From: Martyn White <Martyn.White@arun.gov.uk>
Sent: 28 May 2021 08:56
To: Planning.Responses <Planning.Responses@arun.gov.uk>
Subject: AB/55/21/L

AB/55/21/L

61 High Street Arundel BN18 9AJ

Listed building consent for the removal of the built-in seating, removal of the internal false timber cladding, lowering of height of food service hatch, installation of fold-down access ramp to basement steps, overlay of WC floor materials with single-ply membrane & 1 No. illuminated halo advertisement on front elevation

External Fascia Signage

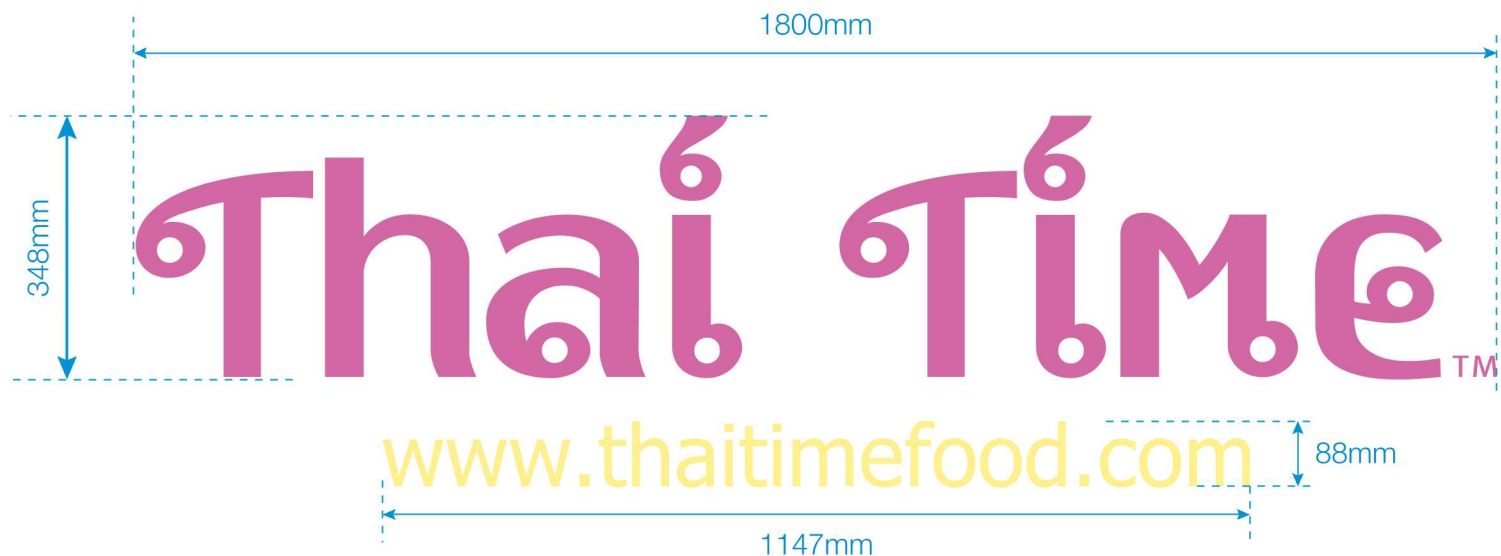
Whilst the lettering of the advertisement is of a reasonably simple design which means that it does not detract from the principal elevation of the building, the proposed colour is somewhat bright, and not fully appropriate for the listed building. However, the materials are considered to be acceptable, with what appears to be a limited amount of lighting. The method of fixing the lettering should be such that it utilises any existing fixing points or is attached into the mortar, as opposed to the bricks.
